Submissions Report

Punchbowl, Affordable Housing, State Significant Development

150 The Boulevard and 34 Dudley Street, Punchbowl

SSD-83256463

Drawing Title Sightline Analysis

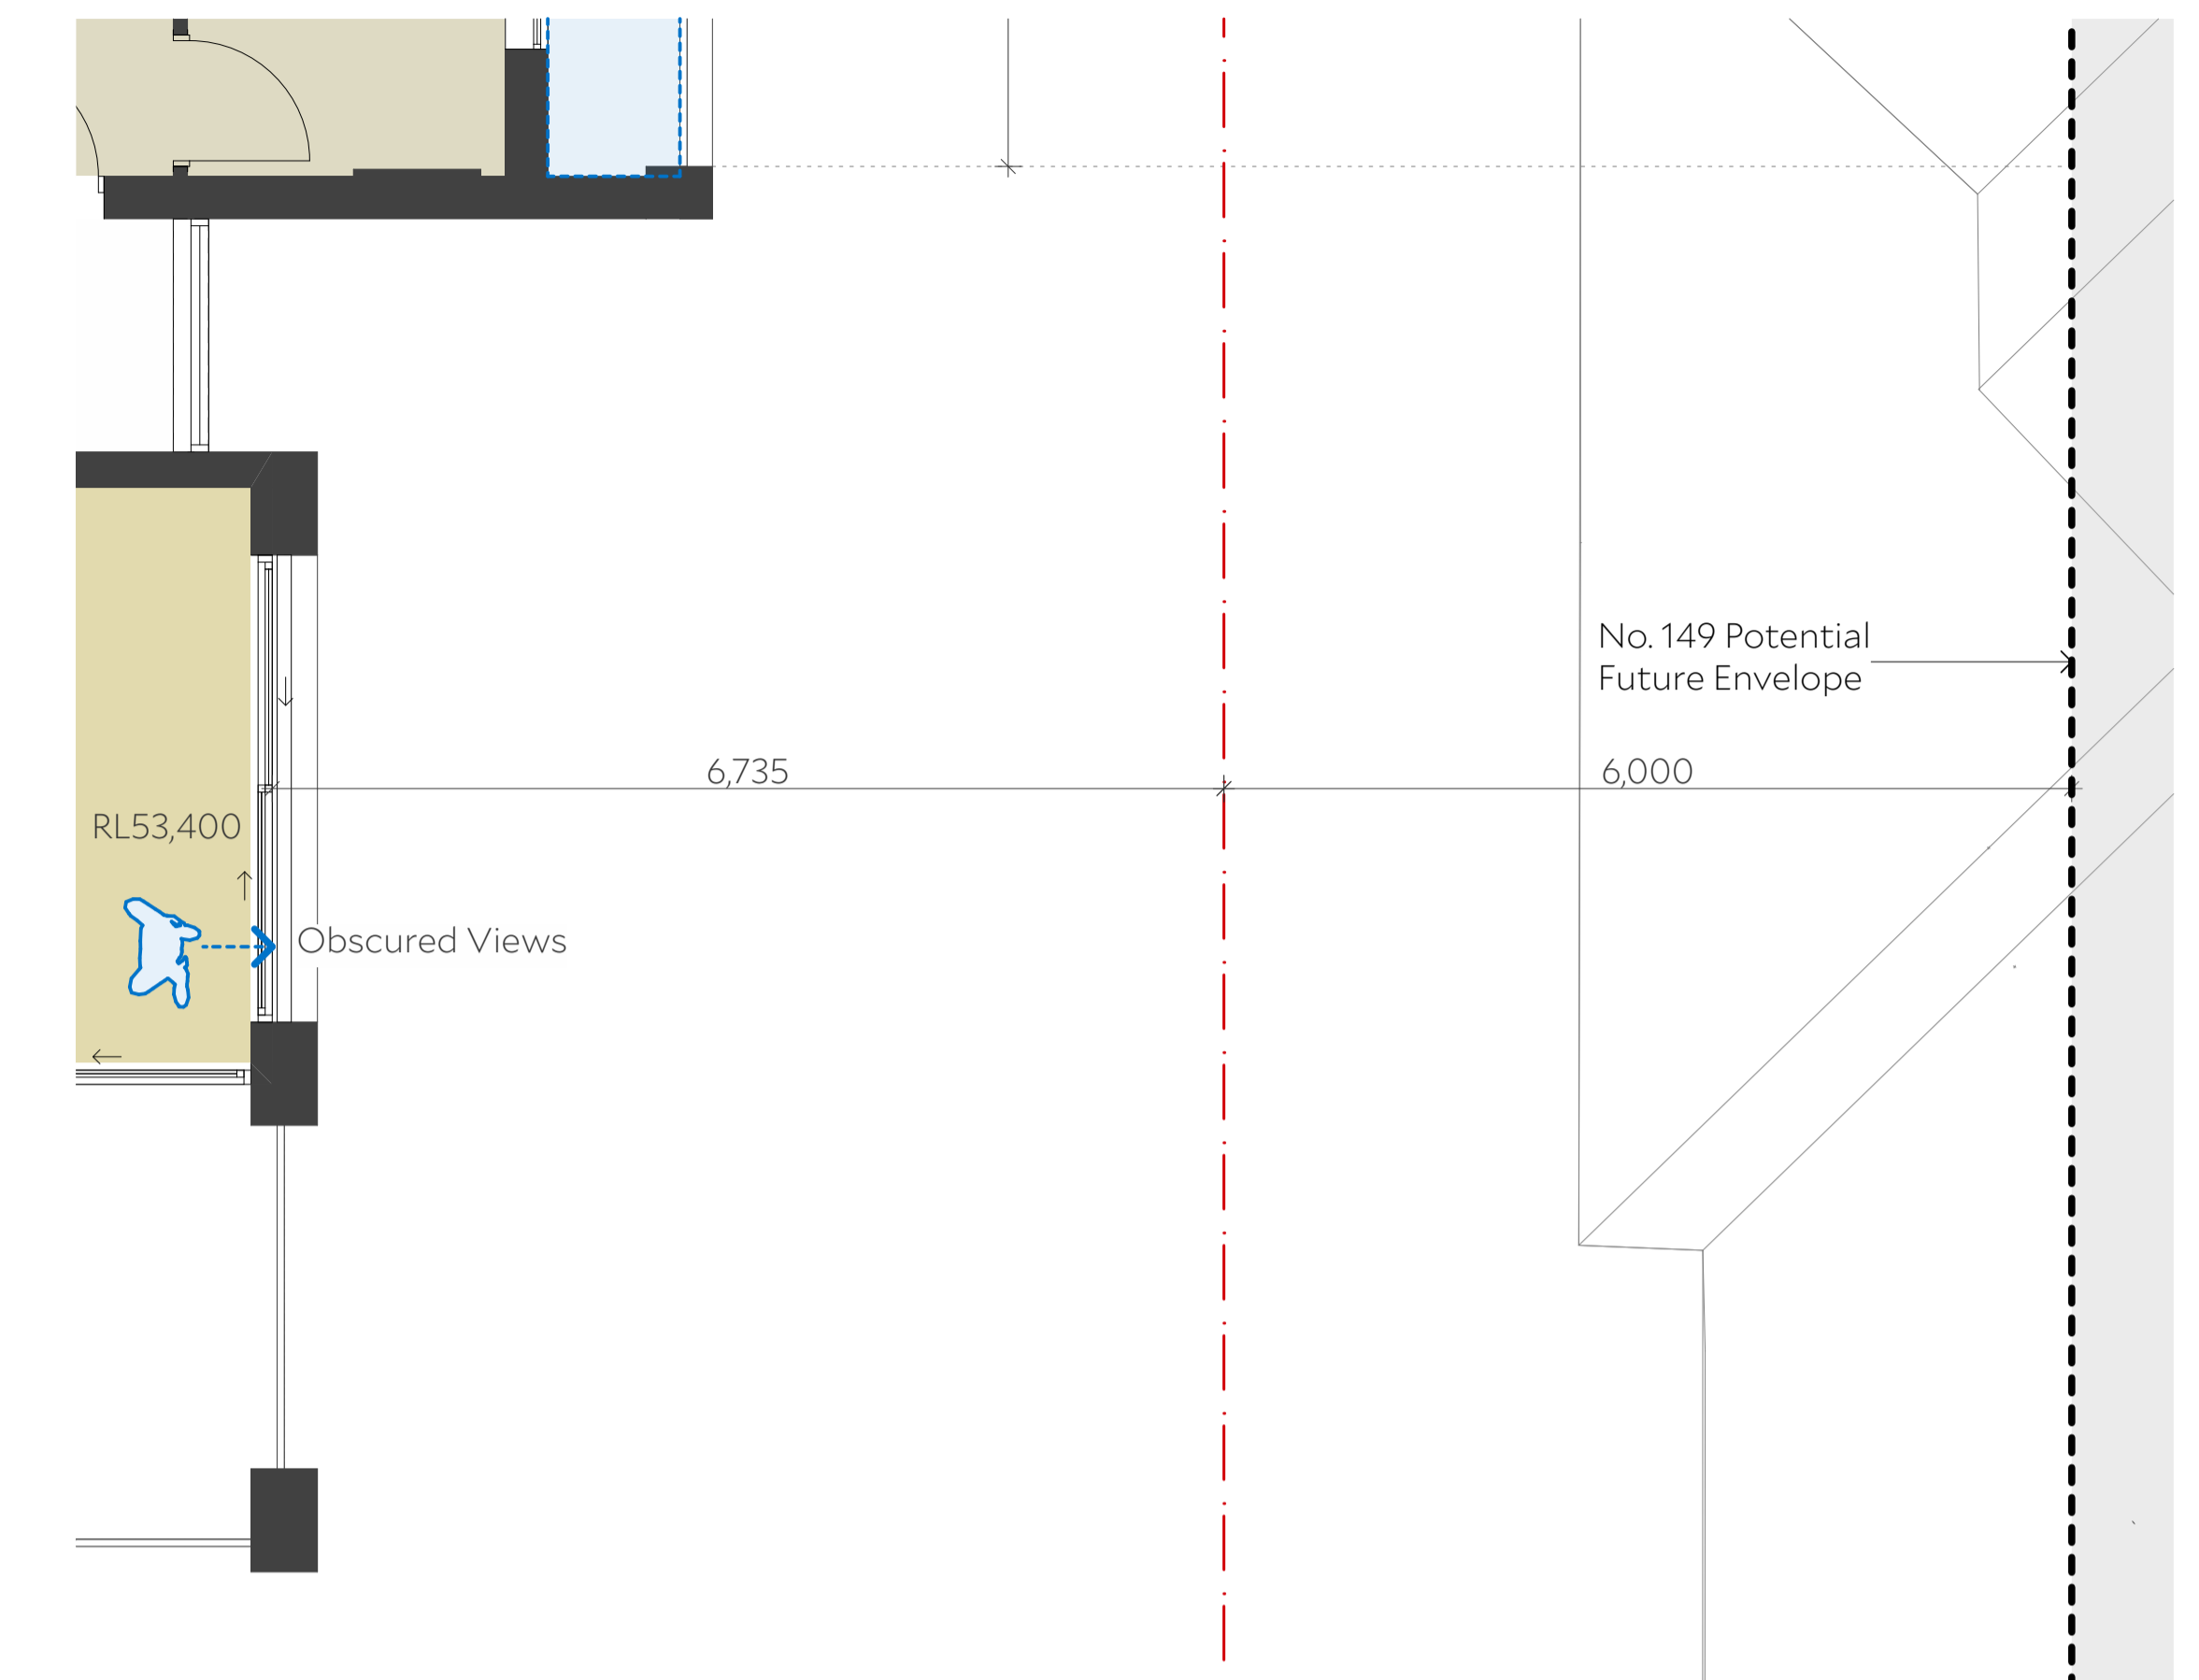
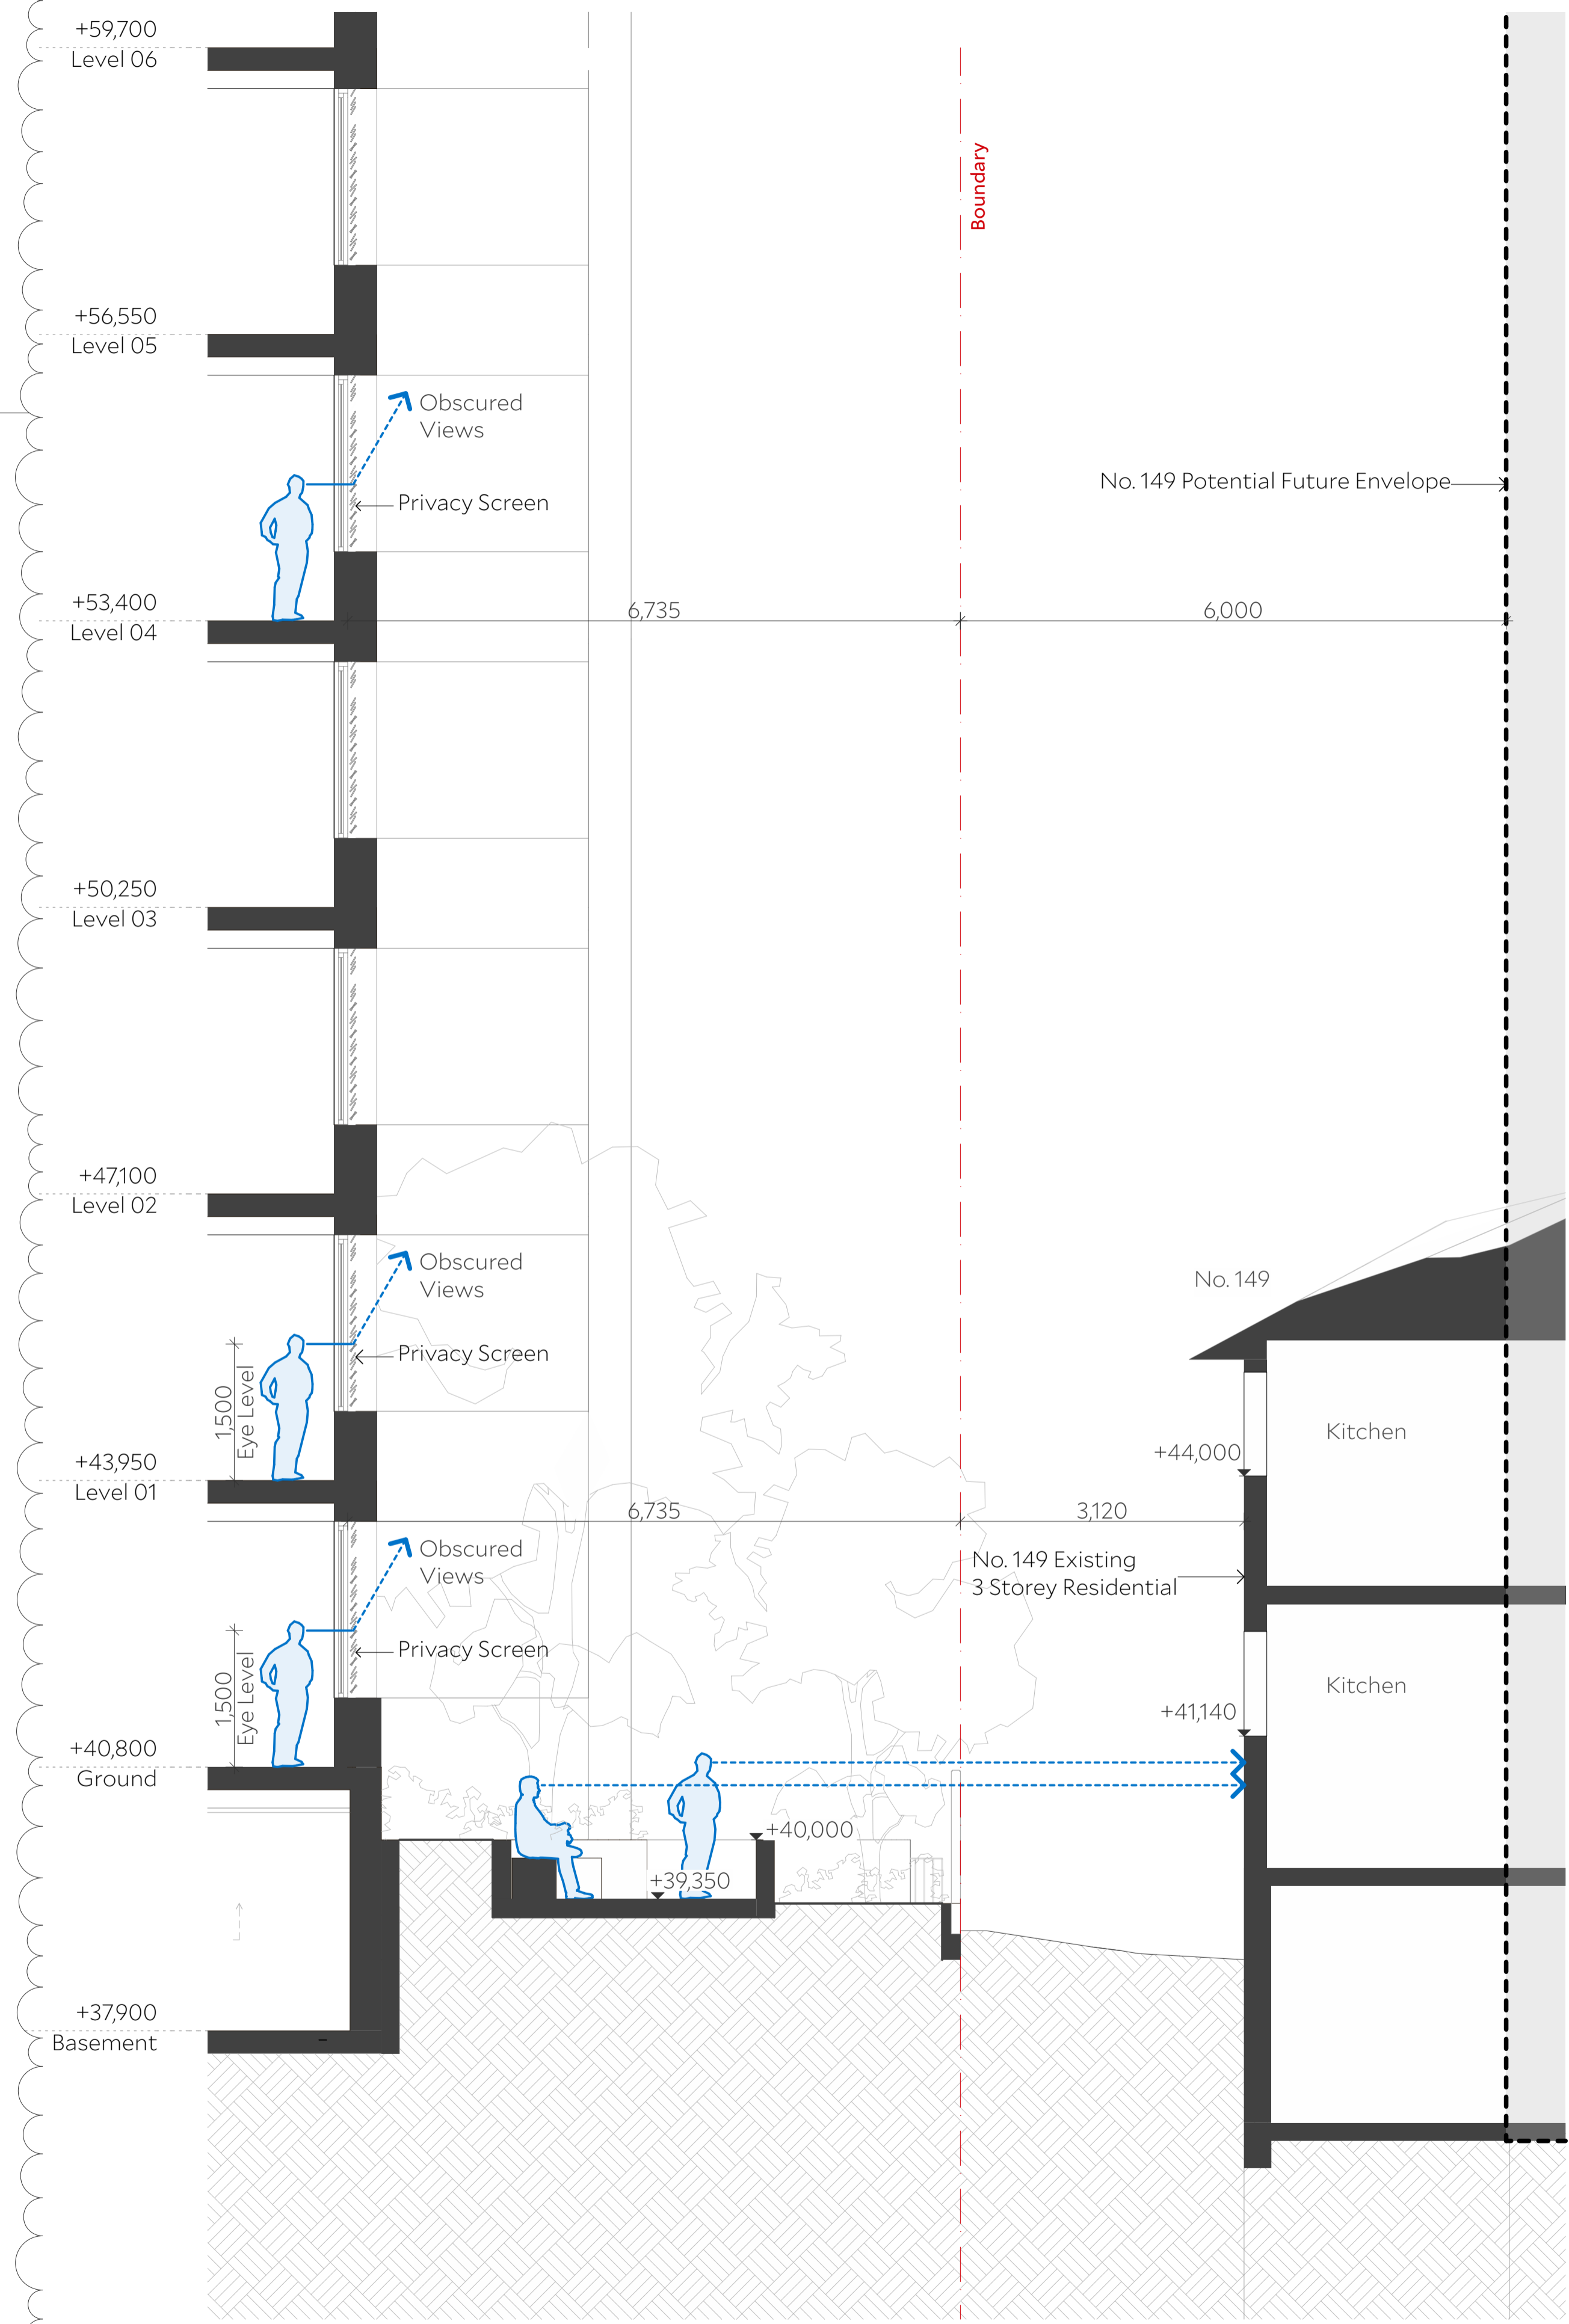
No.	Issue raised	Response
	across all levels to improve solar access or demonstrate why this cannot be achieved.	
2.5	Provide details to demonstrate how adequate privacy is achieved to ground floor courtyards of apartments fronting communal open space (apartments A.G06 and A.G07).	The proposed landscaped pathways located in front of the ground floor apartments fronting the communal open space (apartments A.G06 and A.G07) have been repositioned to move the pathways further from the apartments to improve privacy. Further, as shown on the updated Architectural Plans at Appendix B, privacy screens have been incorporated on the balconies of these ground floor apartments to ensure a high level of privacy is achieved.
